WEST SUSSEX COUNTY COUNCIL CONSULTATION

TO:	Arun District Council FAO: Simon Davis
FROM:	Alison Meeus Highways, WSCC
DATE:	01/08/2018
LOCATION:	34-44 Carlton Avenue, Rose Green, Bognor Regis
SUBJECT:	<u>AW-130-18-OUT</u> Further information submitted regarding swept path analysis of refuse and fire appliance.
DATE OF SITE VISIT:	n/a
RECOMMENDATION:	☒ Advice ☐ Objection ☐ Modification ☒ No Objection ☐ More Information ☐ Refusal
S106 CONTRIBUTION TOTAL:	£ See below for breakdown.

1645-001

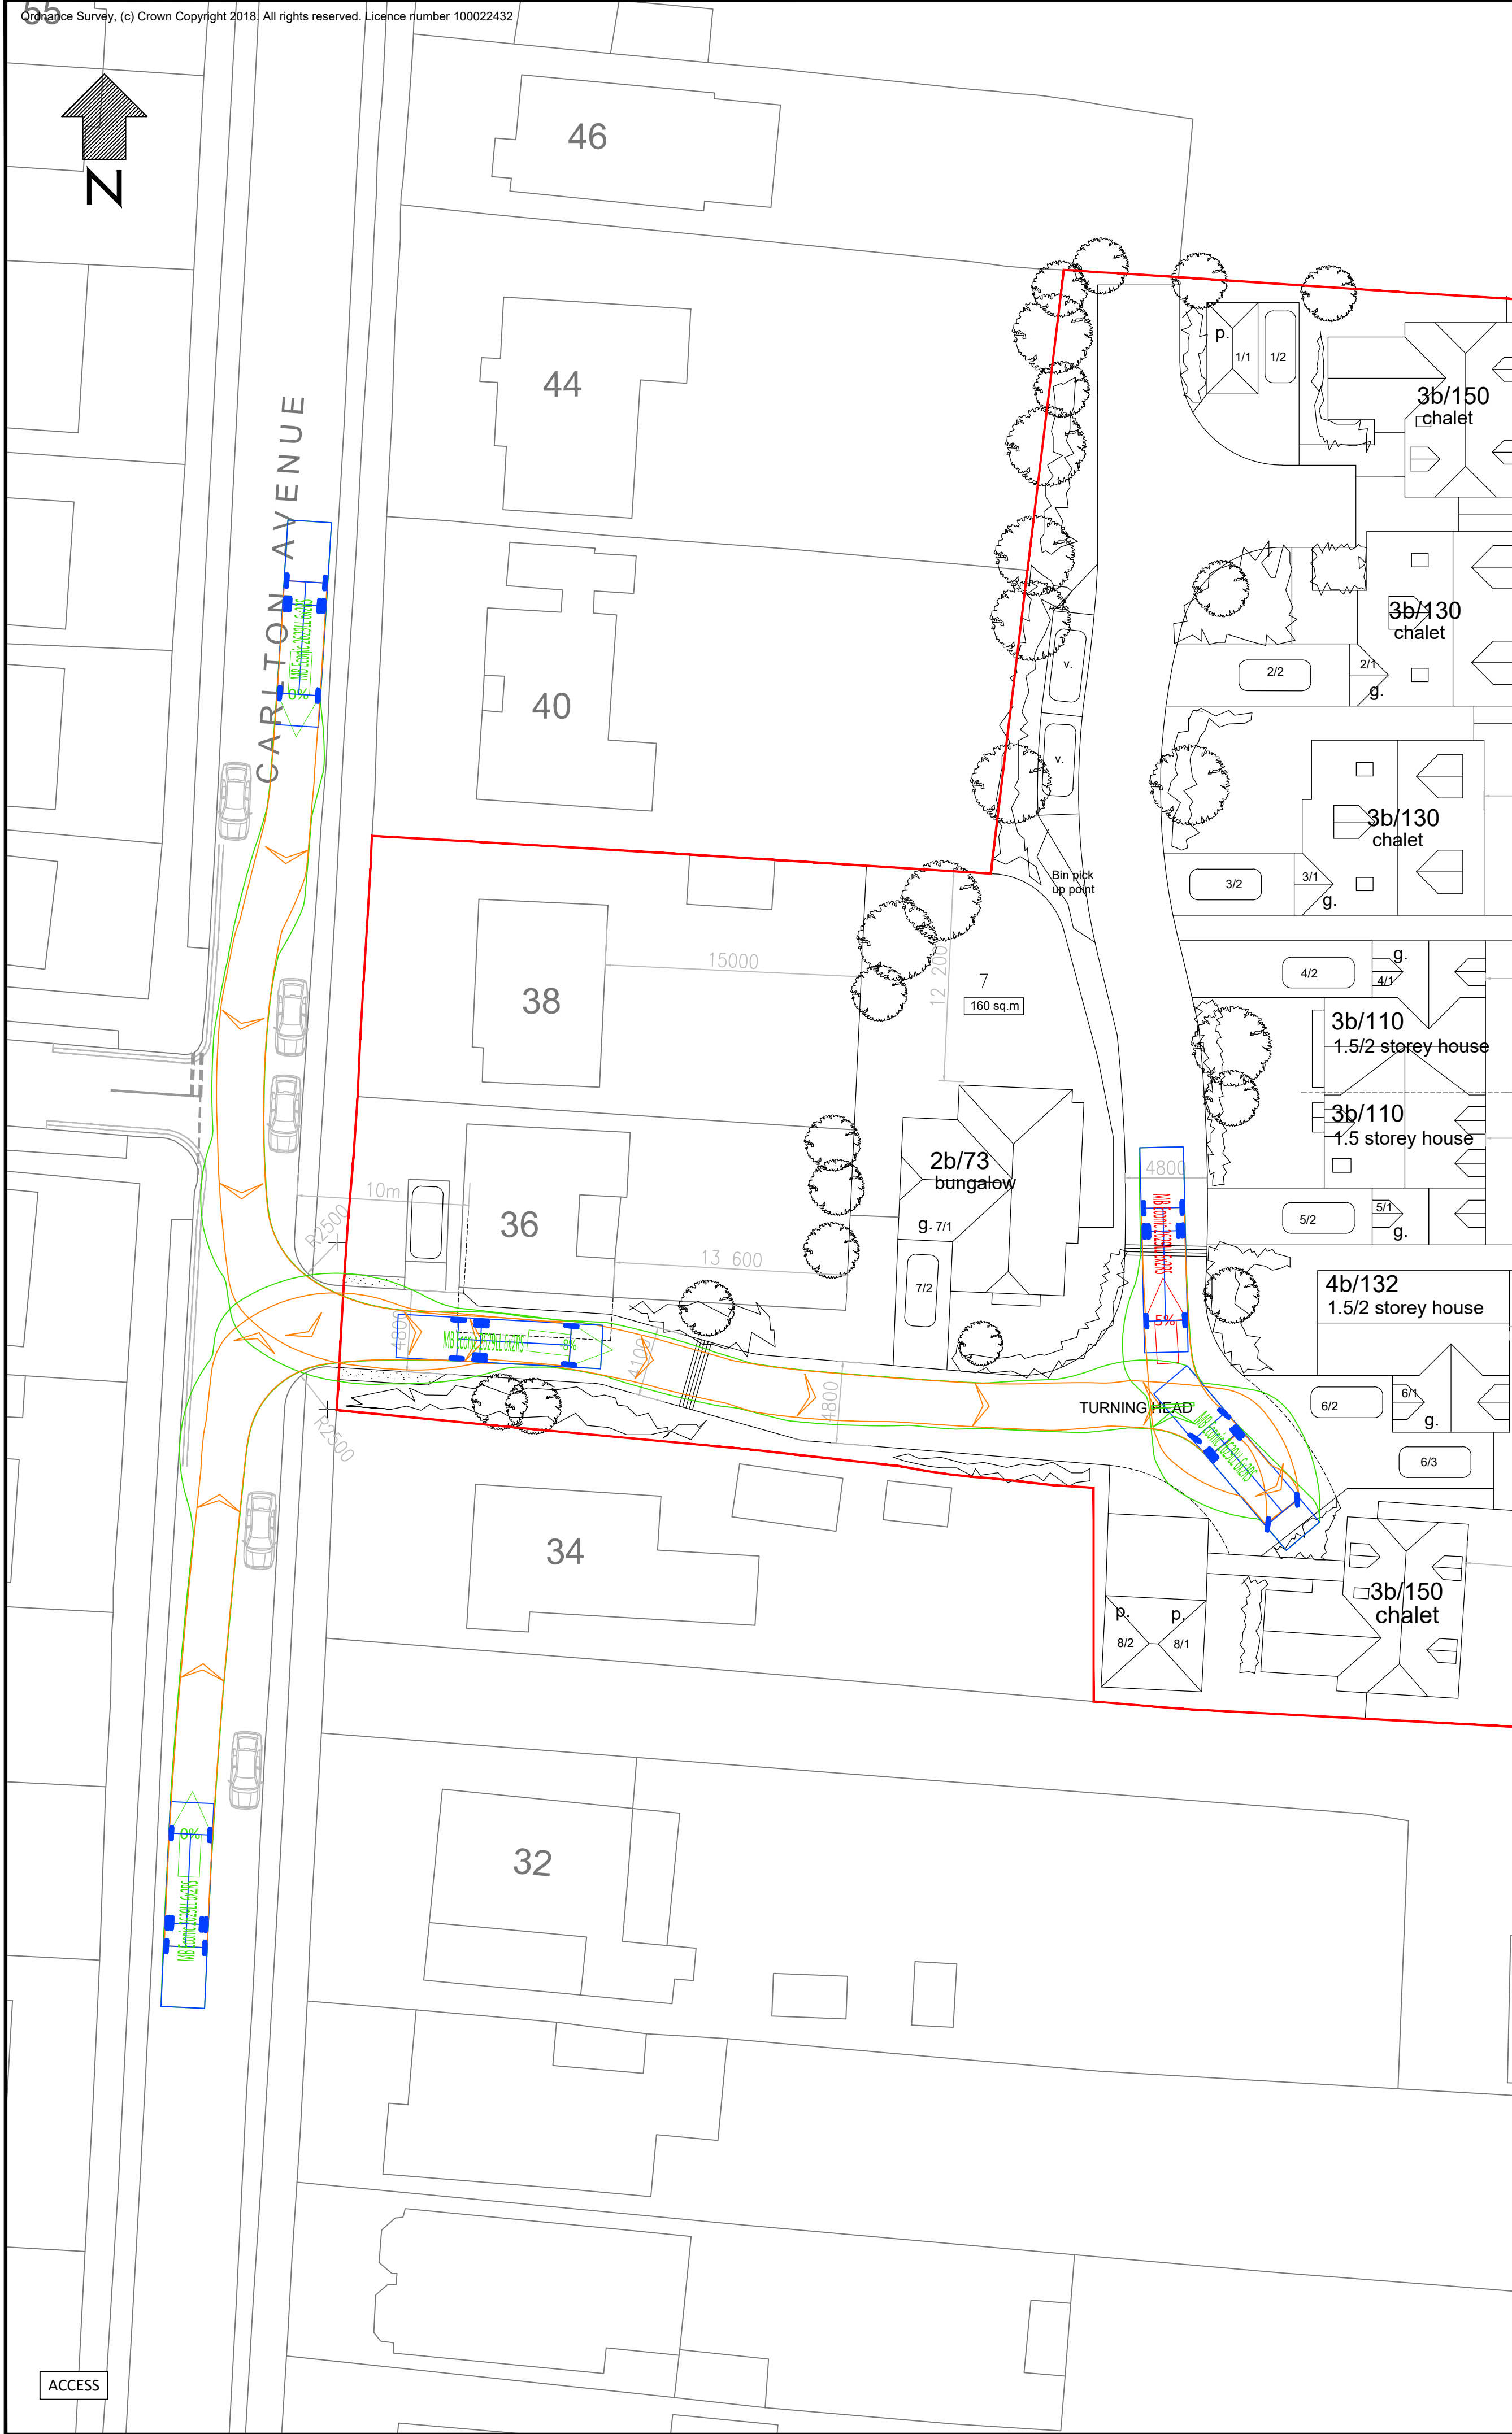
1. Swept path analysis of an ADC refuse vehicle 1645-001
2. Swept path analysis of an DB32 Fire Appliance vehicle 1645-002

WSCC are satisfied both types of larger vehicle are able to make the turn in and out of the proposed new access onto Carlton Avenue, provided cars do not park any closer to the access than shown. Turning heads are also provided within the site which can accommodate both types of vehicle.

Given the times of day in which these vehicles will be operating it is uncertain if more cars could be parked within Carlton Avenue than the simulation shows. With this in mind WSCC would like to propose a condition to for double yellow lines to be included at the new access to ensure no parking can take place at any time on either side. This will be provided at a cost to the developer and should be progressed with the WSCC Traffic Regulation Team, alongside the S278 agreement as soon as possible to ensure the safe ingress and egress of larger vehicles.

No development shall be commenced until such time as a Traffic Regulation Order, or revision to an existing order, securing the provision of no waiting at any time restrictions in accordance with details to be submitted has been approved by the Highway Authority and written confirmation of this approval has been made available to the Local Planning Authority.
